FAO: Planning Department,  
Welwyn Hatfield Borough Council

Ref: 6/2018/0136/LB  
Date: 22/10/2019

## HISTORIC BUILDINGS AND CONSERVATION ADVICE

**RE: *Oshwal Centre, Coopers Lane, Northaw, Potters Bar, EN6 4DG***

DRAWING TITLE
WINDOWS 11B-11C

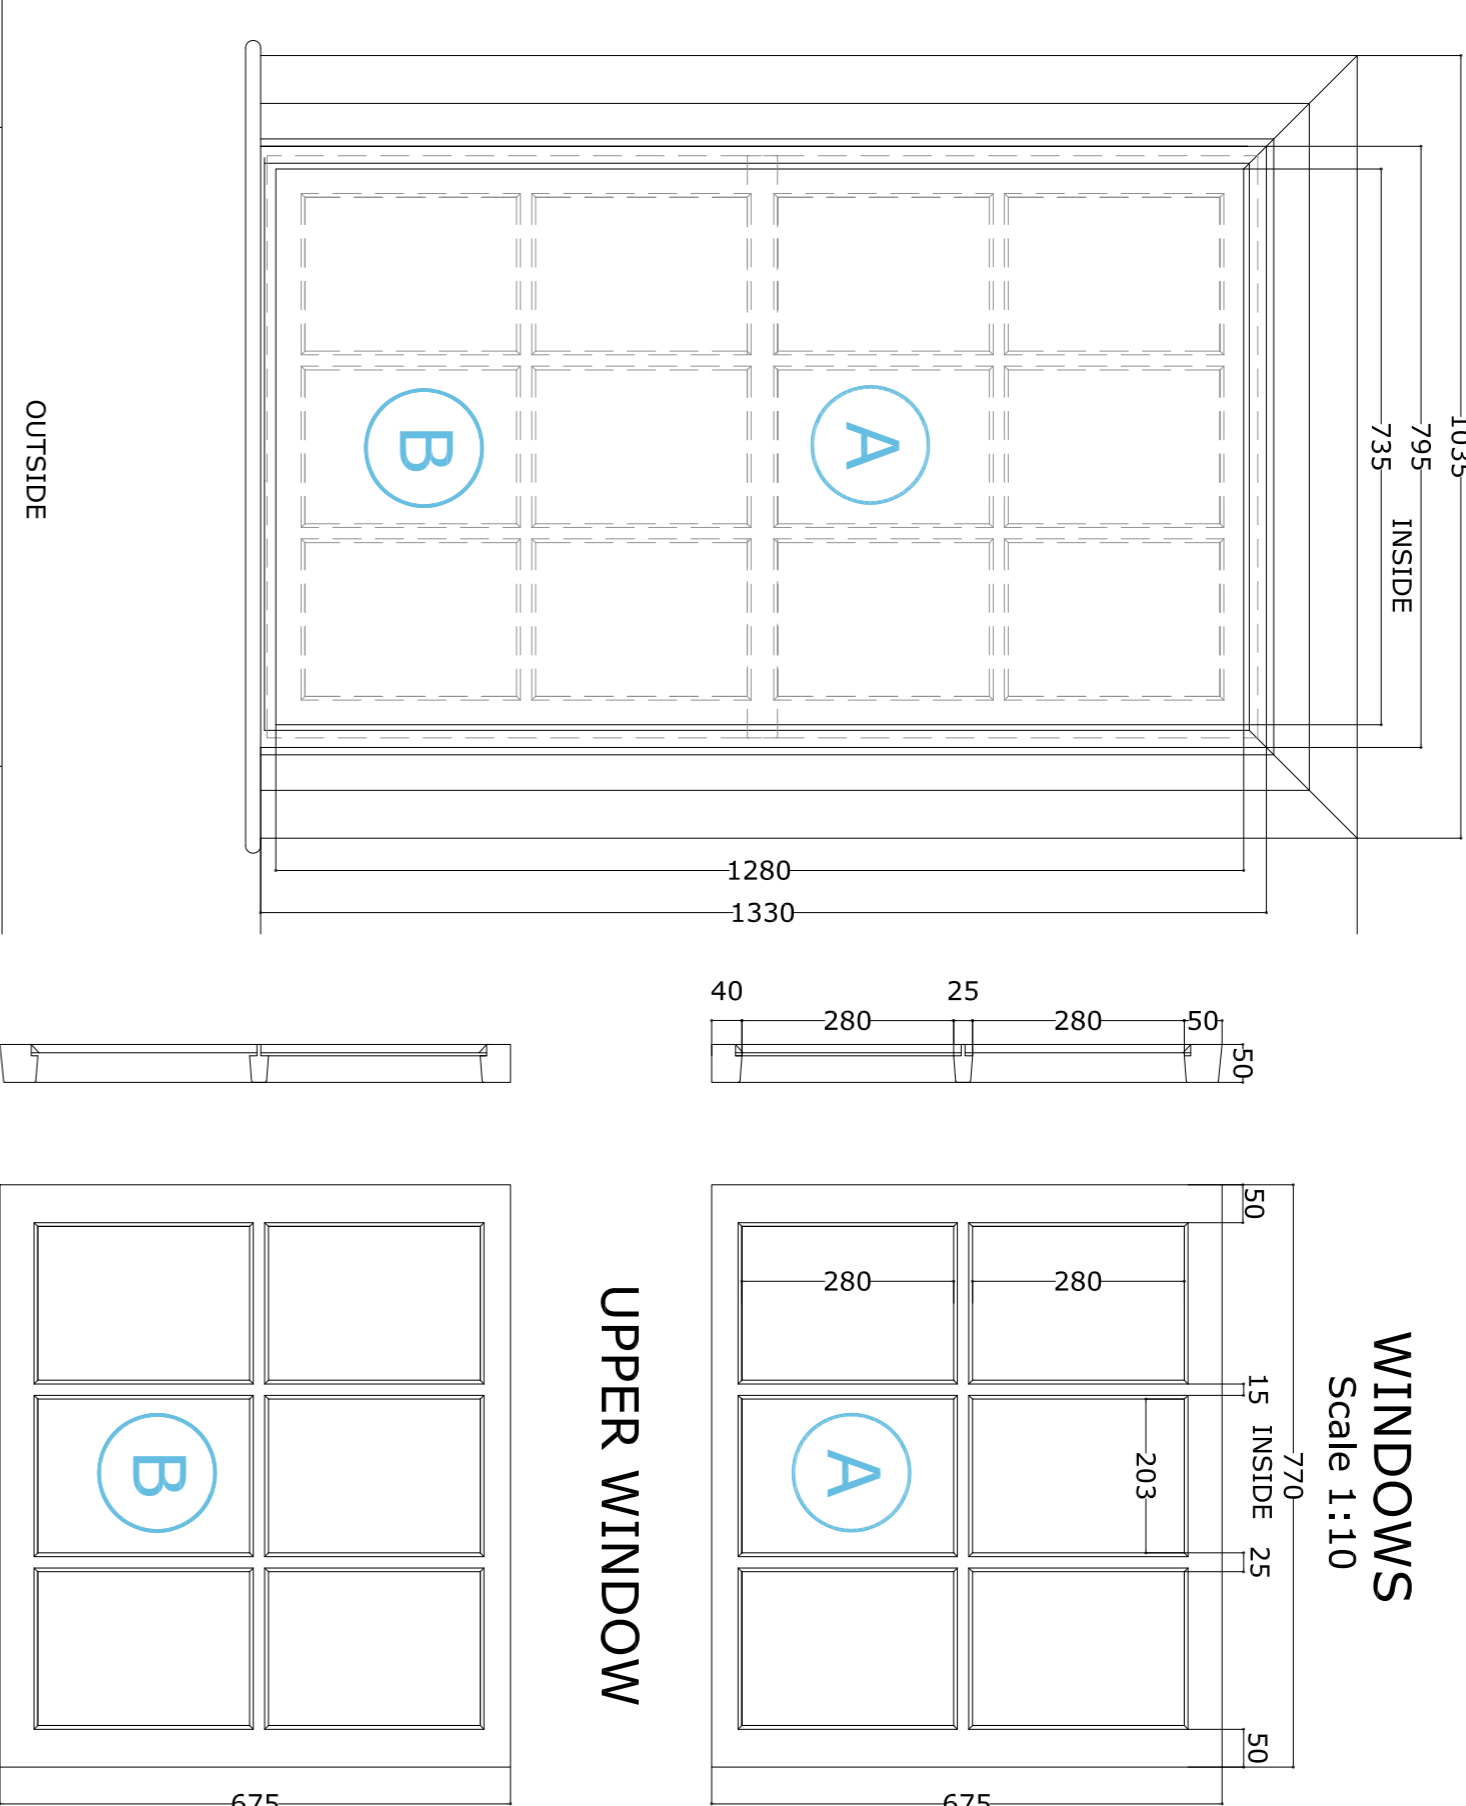
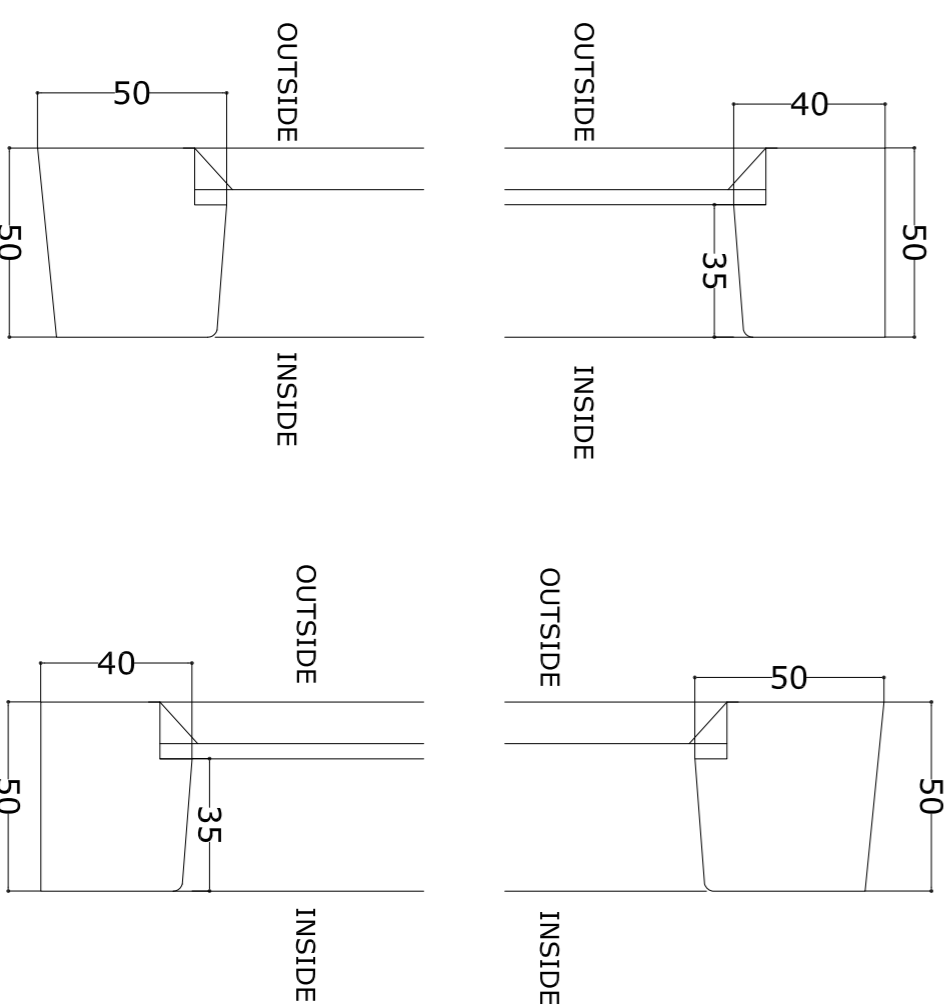
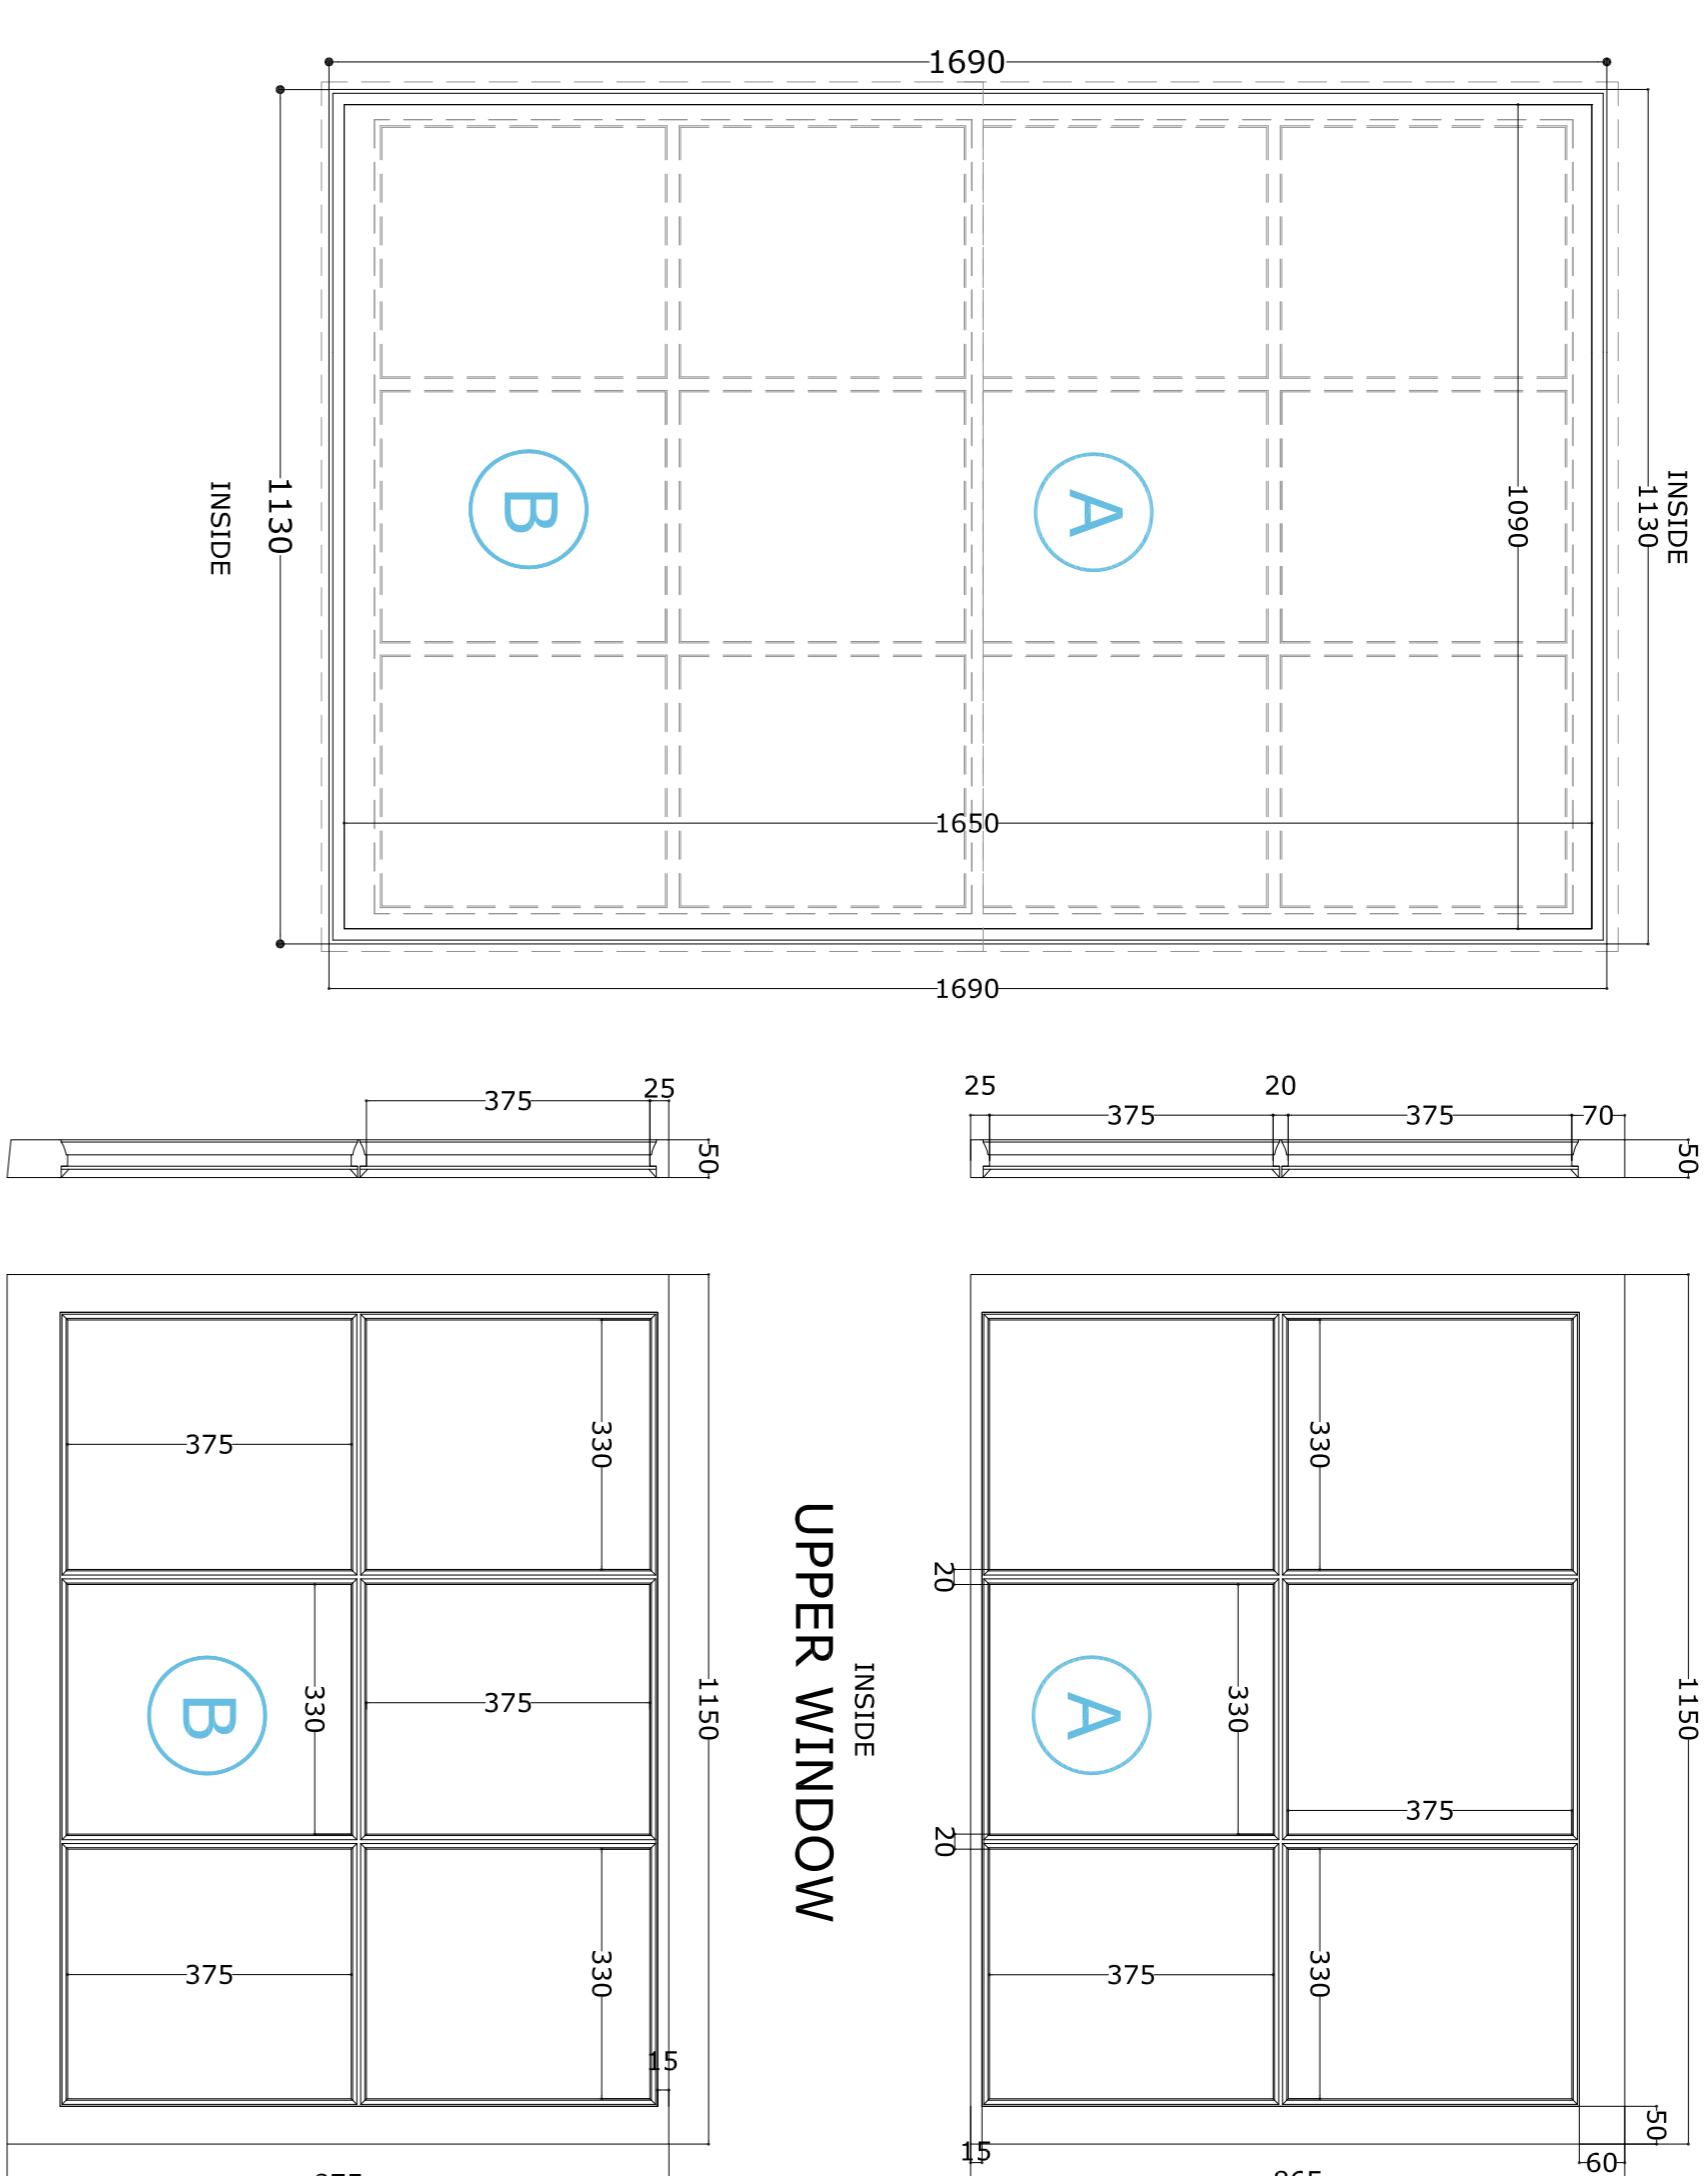
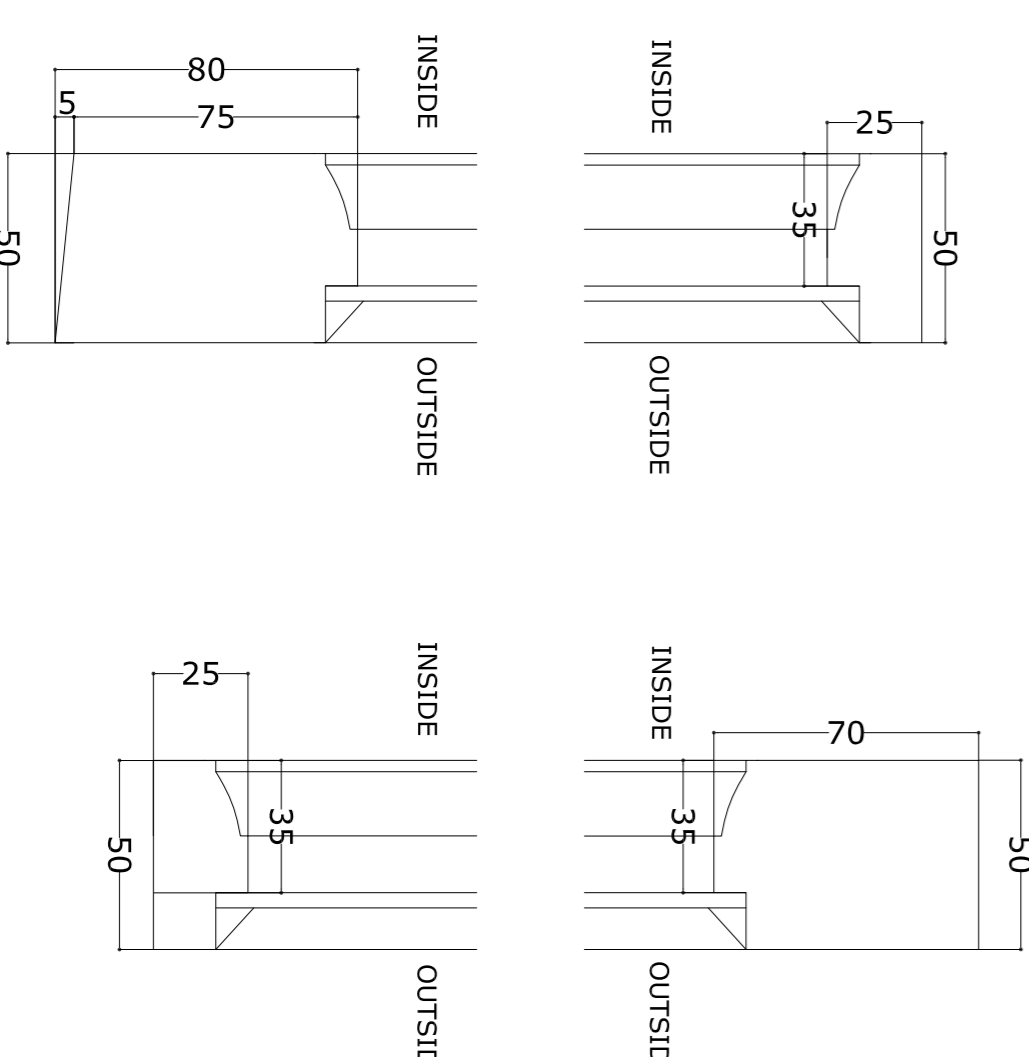
The replacement of the mid-late twentieth century windows (nos. .10, 11b, 11c, 33, 33b, 53, 54, 55 as per paragraph no. 2.14) raises no objection in principle but their replacements should be of a design more appropriate to the historic building, taking reference from the existing historic windows. Elevation and section details of the proposed windows is required to judge their impact on the listed building.
